**RE: DESIGN COMPETITION WAIVER REQUEST
NeW SPACE, 409 Hunter St Newcastle**

MEETING SUBJECT: NeW Space Design Review Panel

PROJECT NAME: NeW Space

DRAWING TITLE
PLAN - LEVEL 5

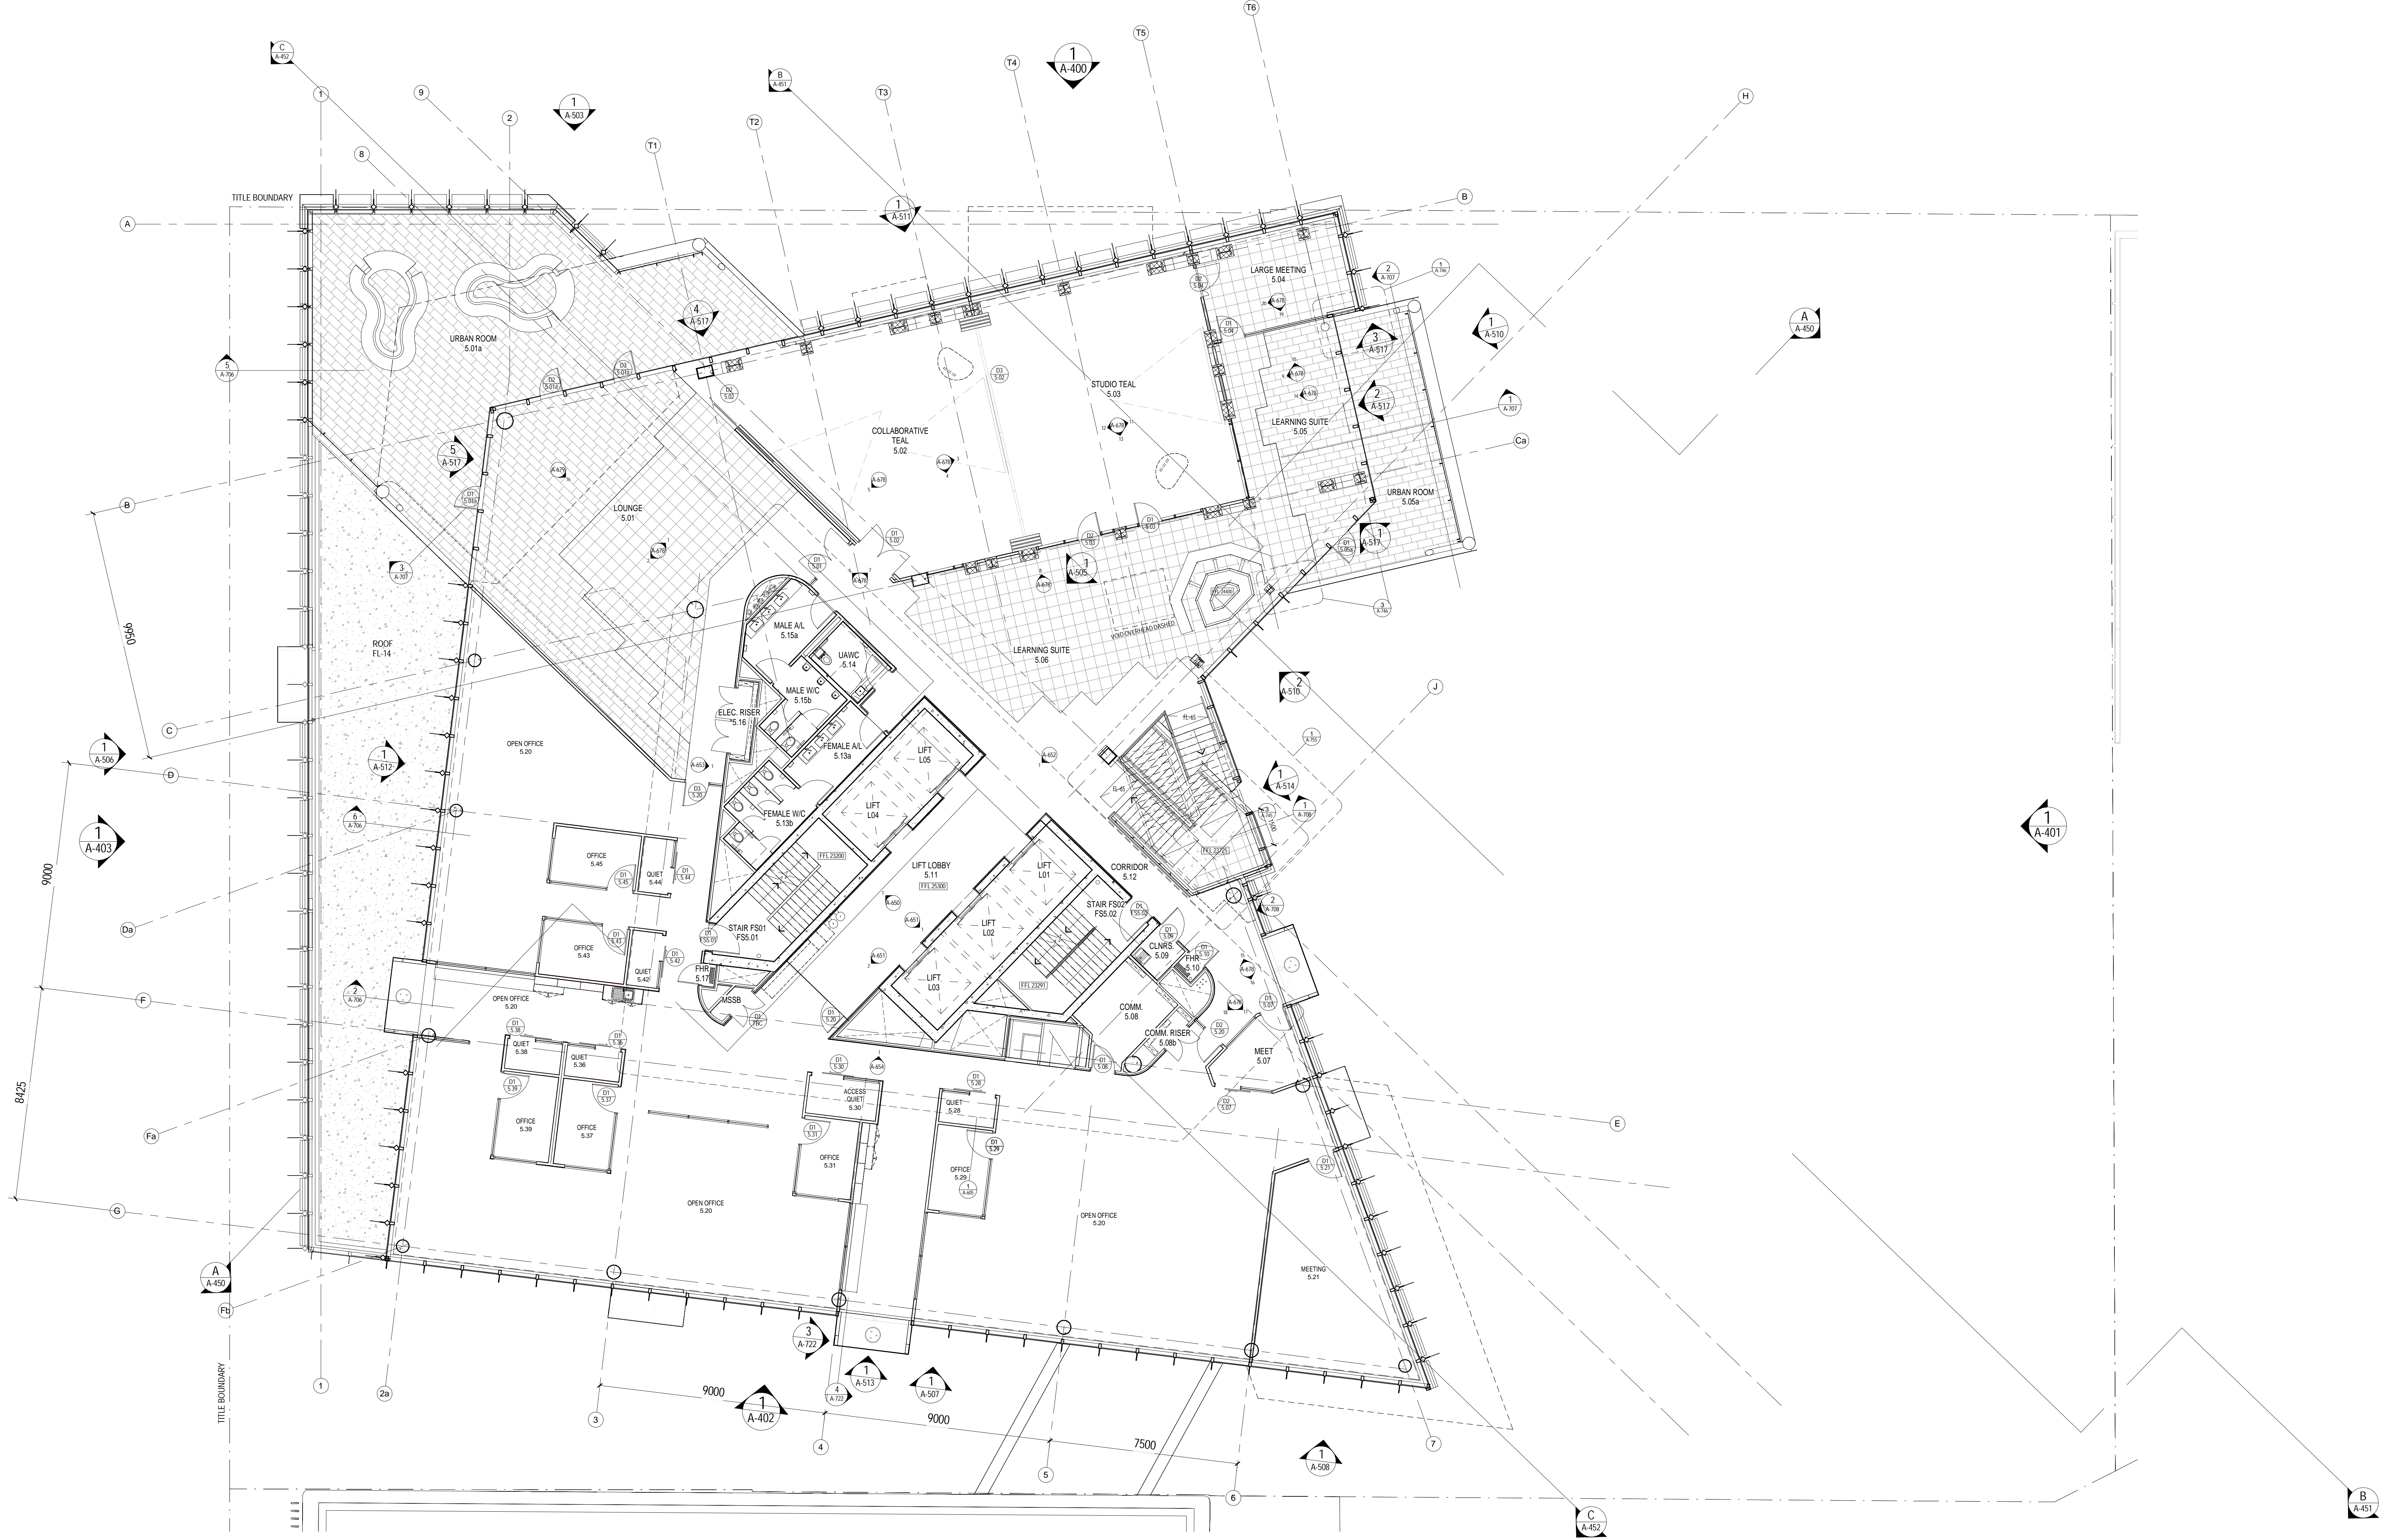
number of alternatives for access to all levels of the building including stairs and elevators.		
4.8	<p>Issue 8 – Depth of Floor Plate</p> <p>PP questioned the depth of the floor plate from glazing to the core on level 3.</p> <p>Response</p> <p>The PDC advised that the general office depth will be 11 metres, with one deeper floorplate on level 4 of 16.8 metres.</p>	To Note	N/A
